**From:** [Bill Booker](#)  
**To:** [A38 Derby Junctions](#)  
**Cc:** [Simon Cope \(simon.cope@eurogarages.com\)](#); [Tim Hancock](#); [Wilson, Andy](#); [Rob Green](#)  
**Subject:** A38 Derby Junctions Schemes  
**Date:** 26 March 2020 08:42:32

Following the postponement of the Hearing on 19<sup>th</sup> March we have, as requested, prepared an update for the Inspector in relation to the issues raised by Euro garages Ltd (EGL). This note has been prepared with input from Mr Tim Hancock and also Mr Simon Cope from EGL. The outstanding issues raised are summarised below under the following headings:

1. A52 access junction
2. A38 Ingress to the site
3. A38 Egress from the site
4. Advance Warning Signage

CUSTOMER TRACKS

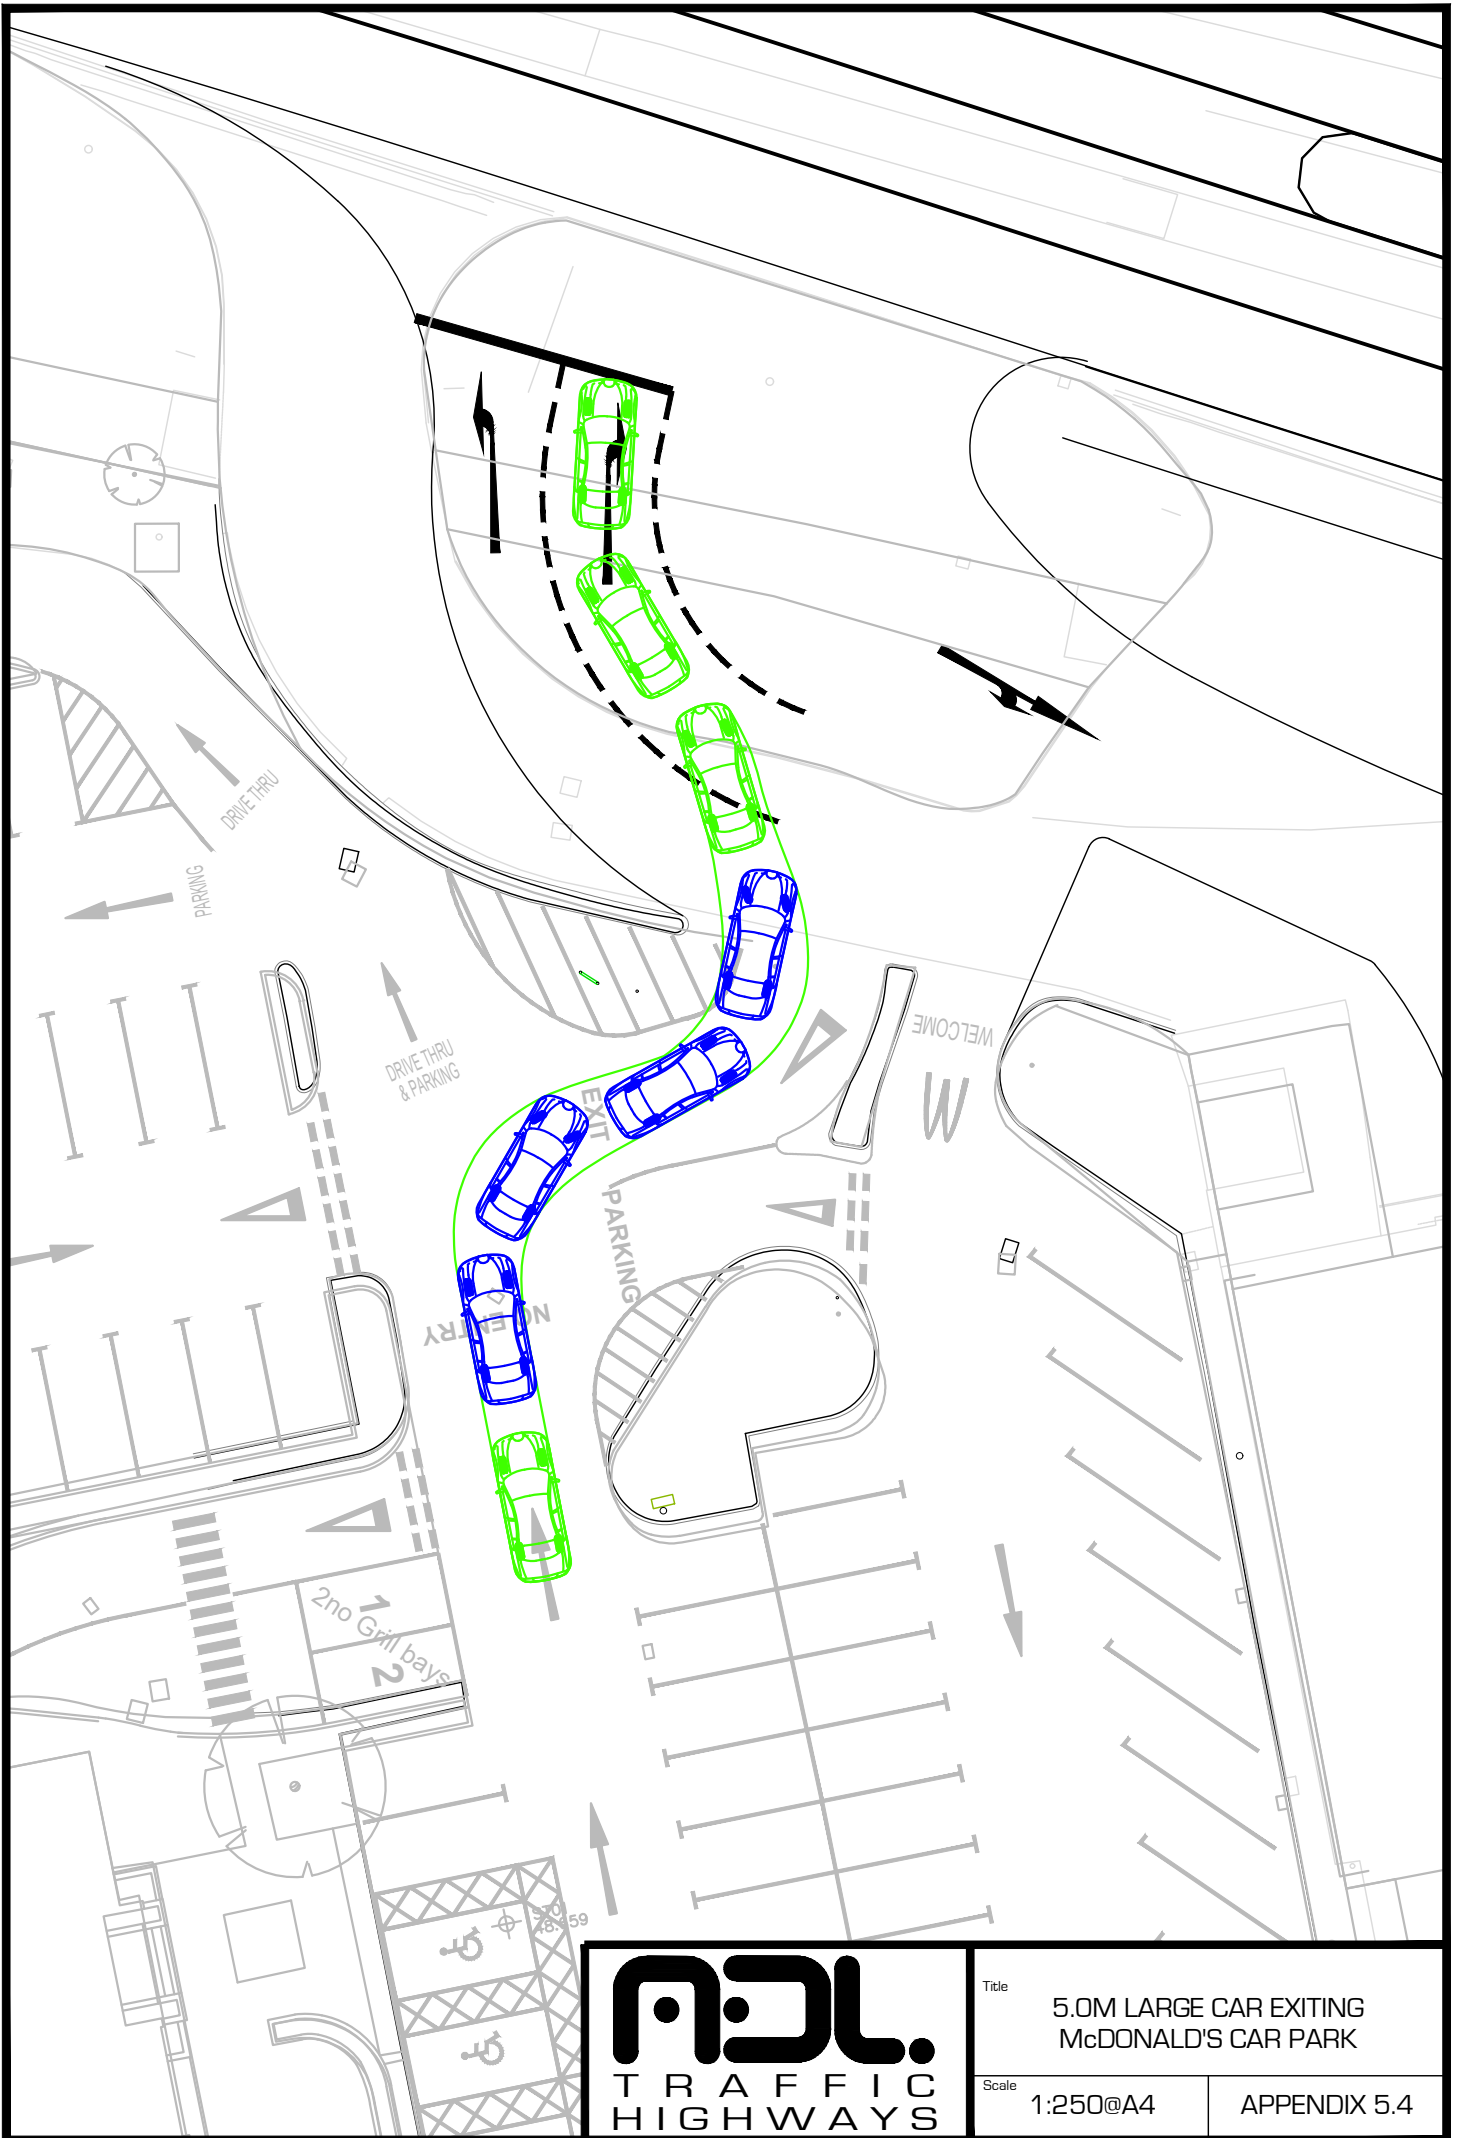
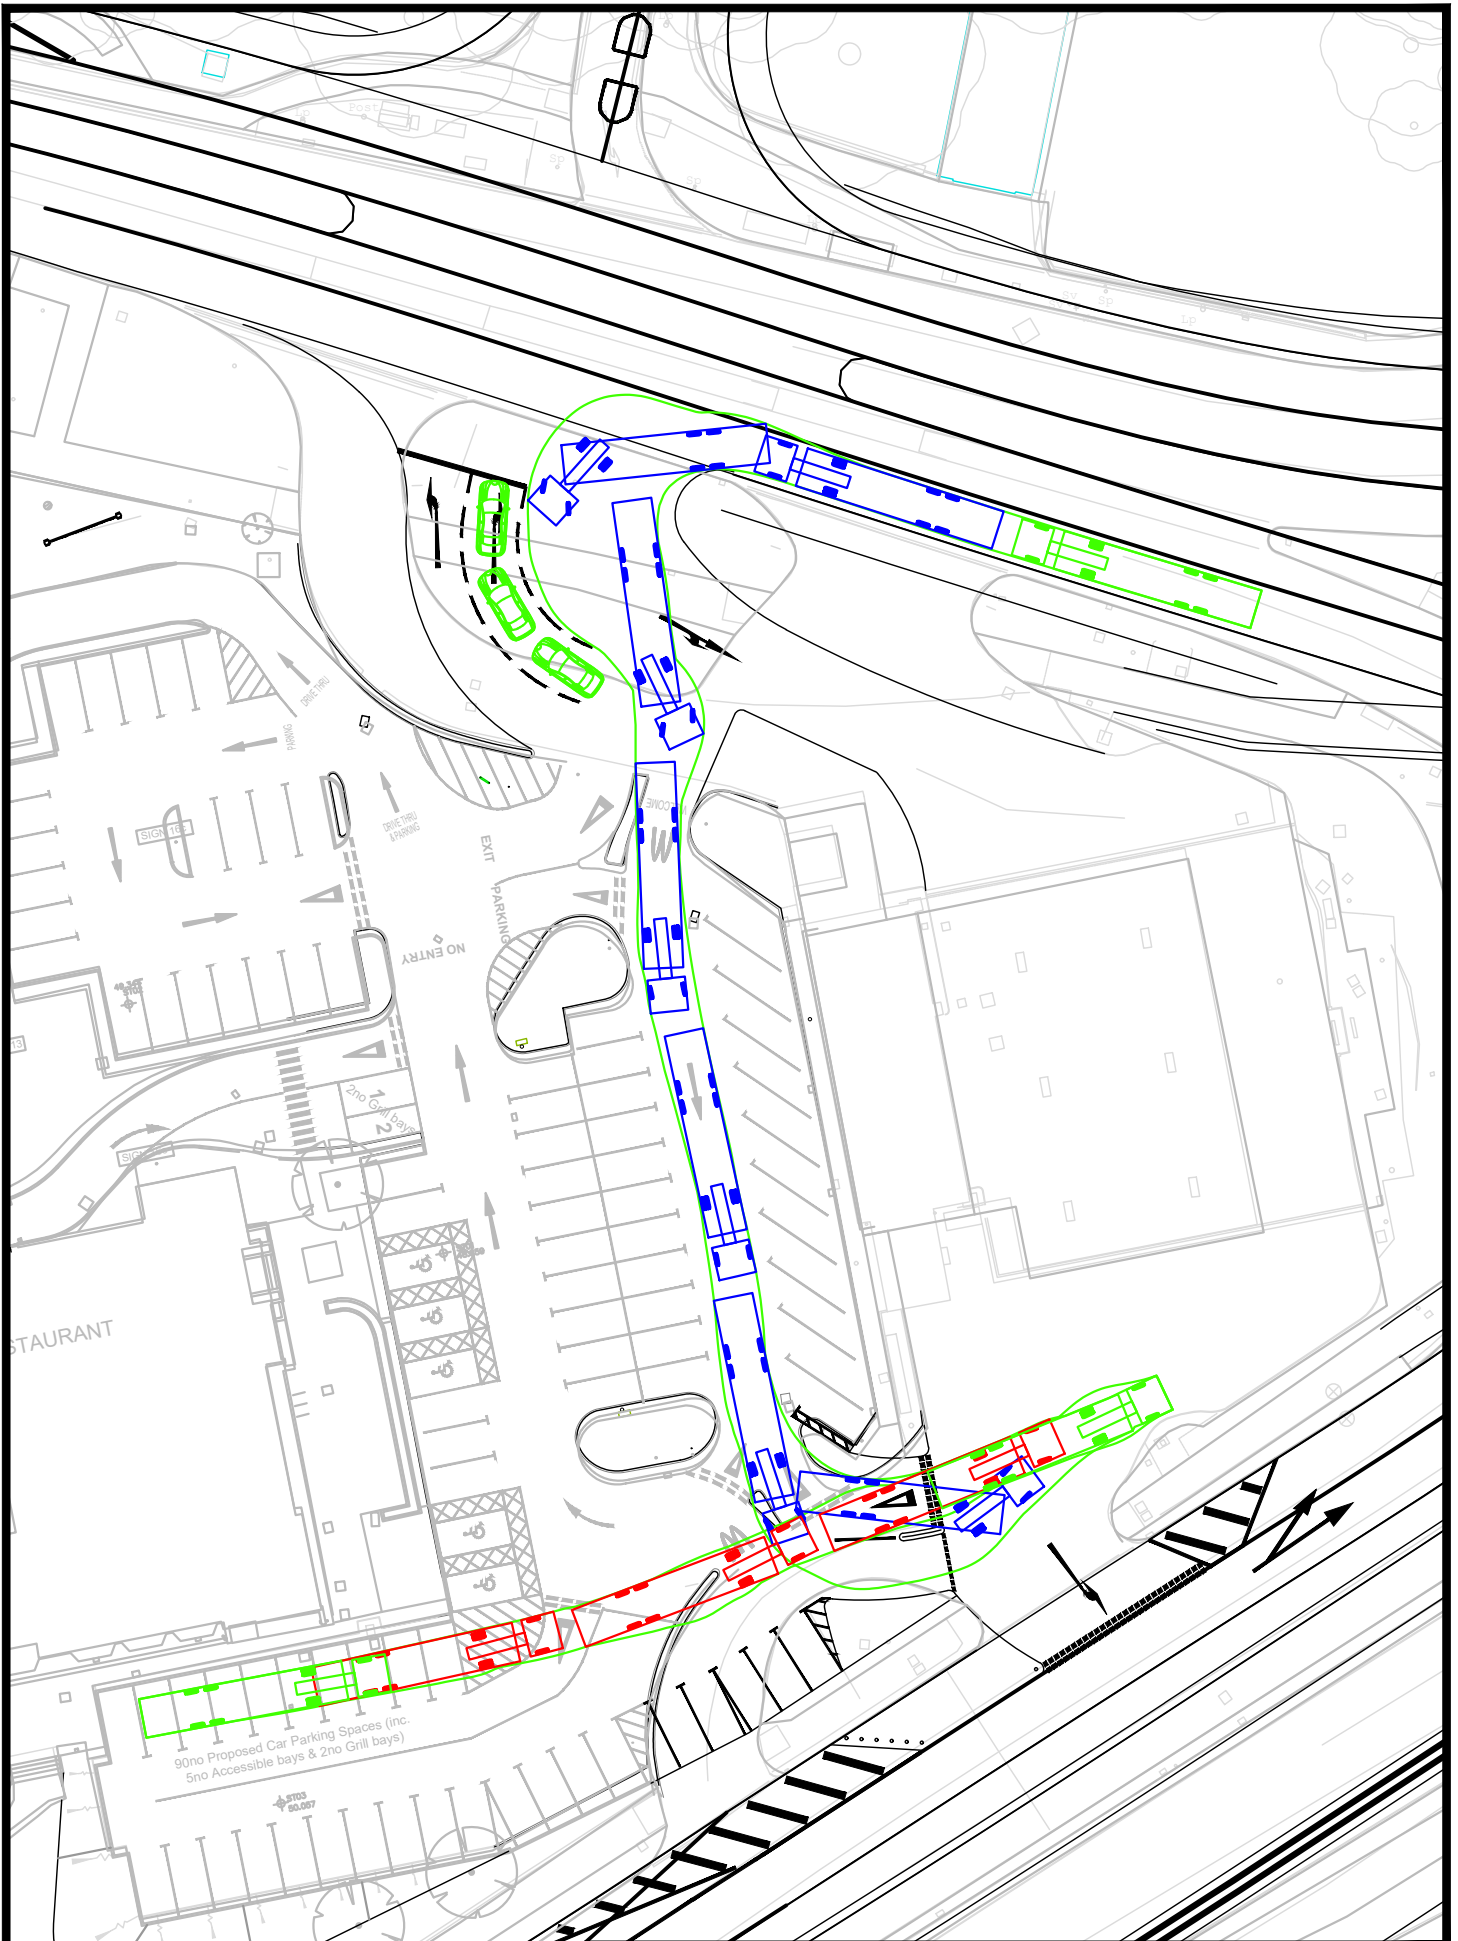
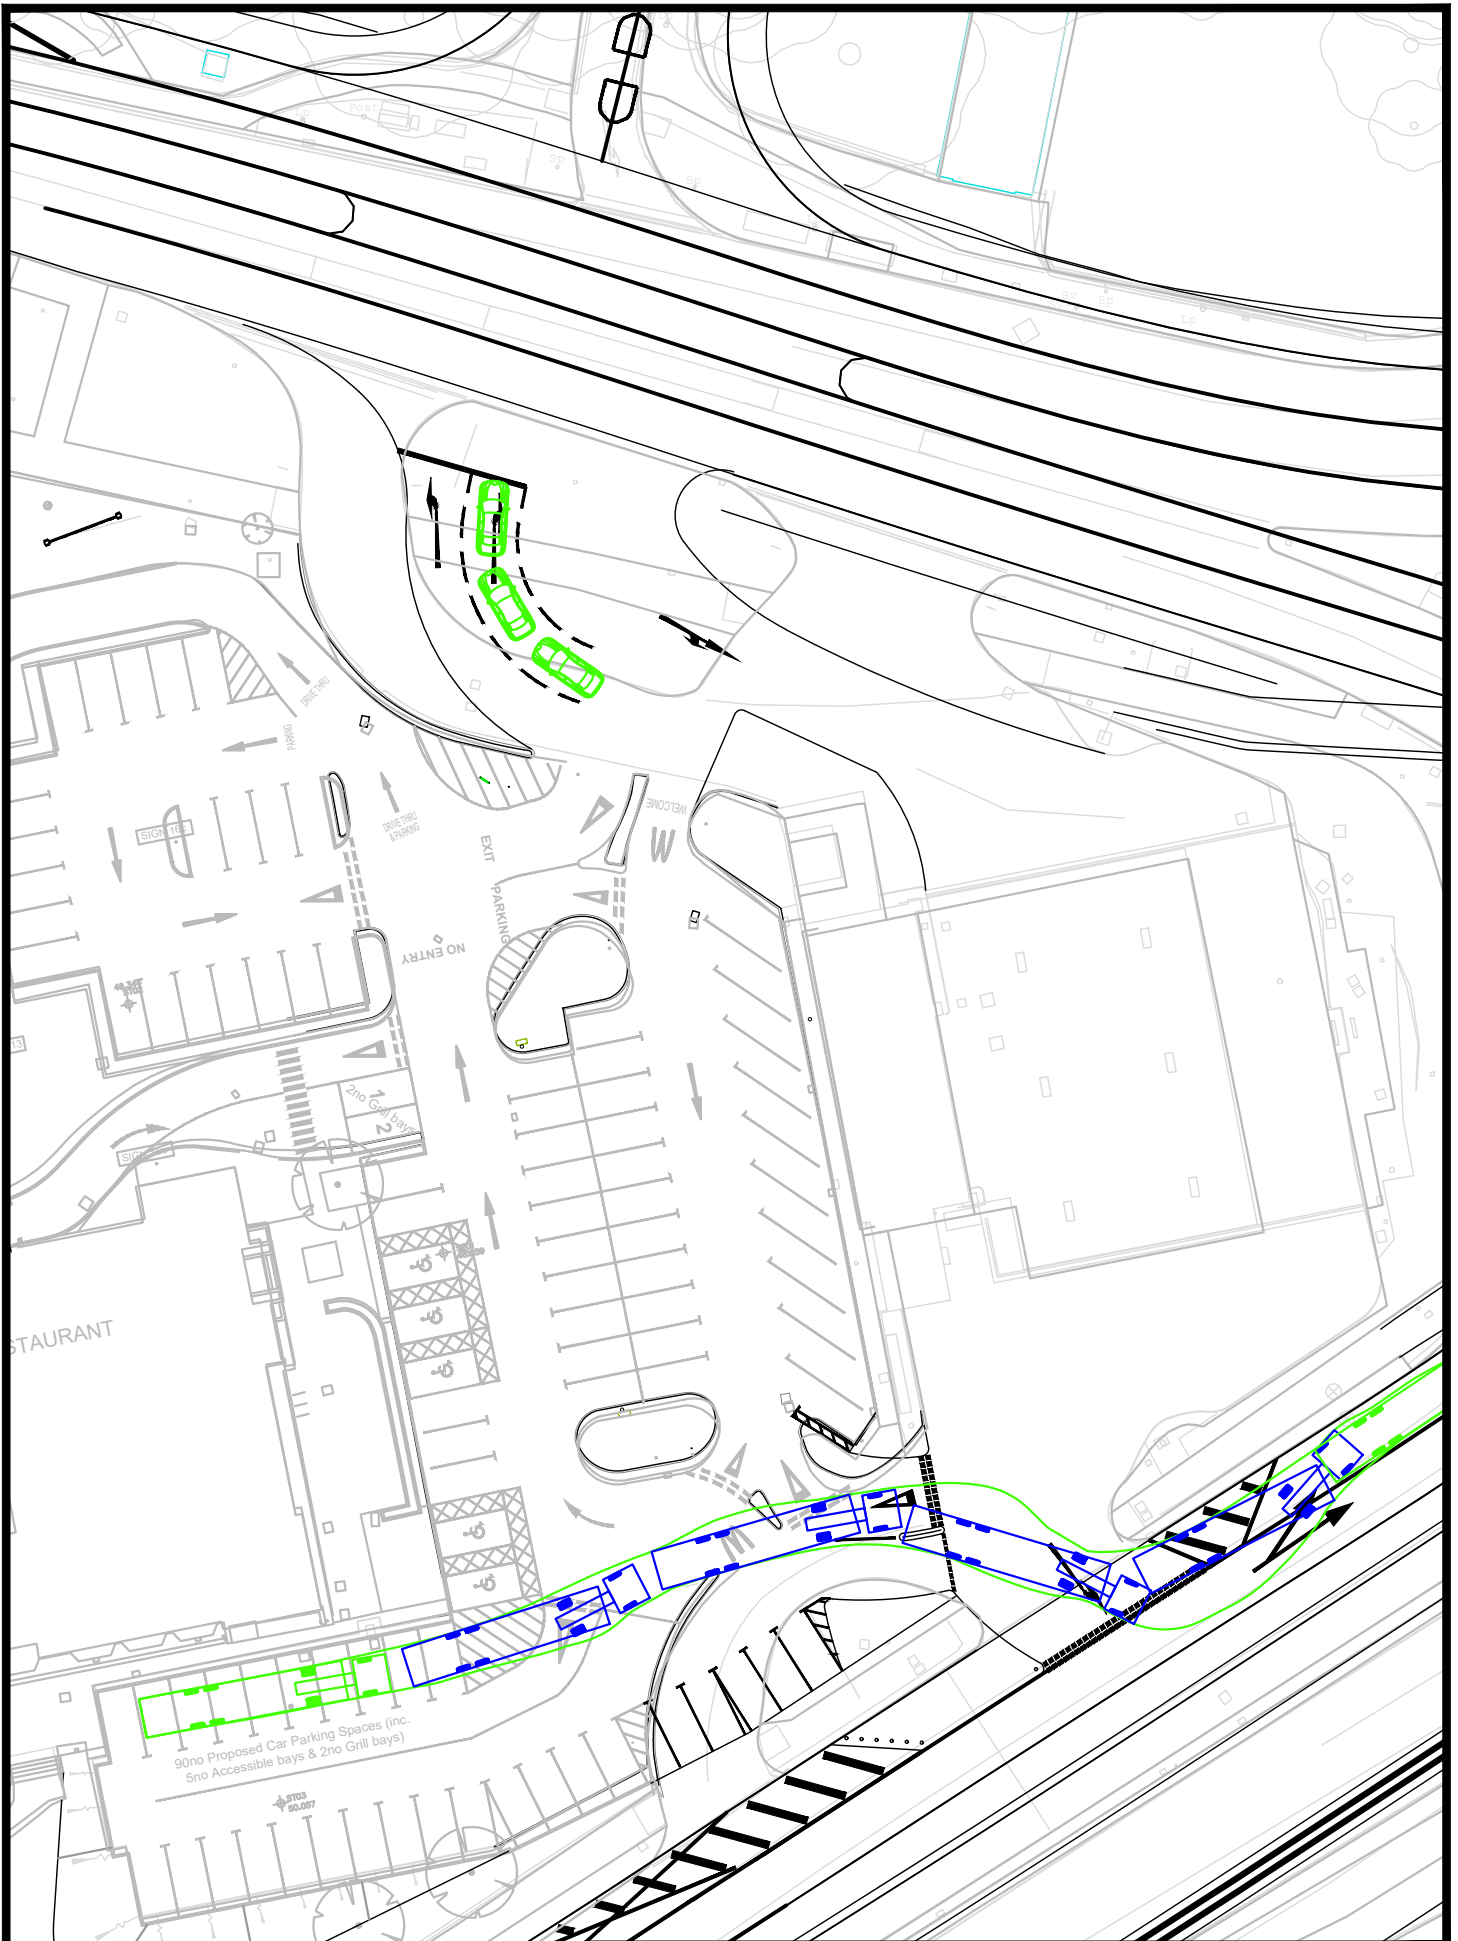
3. The McDonalds delivery / refuse manoeuvres will no longer be able to take place from the A38 and will have to pass through the existing car park using the sub standard A52 access. The swept path of the delivery vehicle illustrates that the vehicle will need to pass onto EGL land in order to make the manoeuvre. No allowance for this new right has been made in the DCO. It is not considered appropriate to rely upon McDonalds and EGL to have to come to an arrangement on this matter. **This point needs to be clarified by the Applicant.**
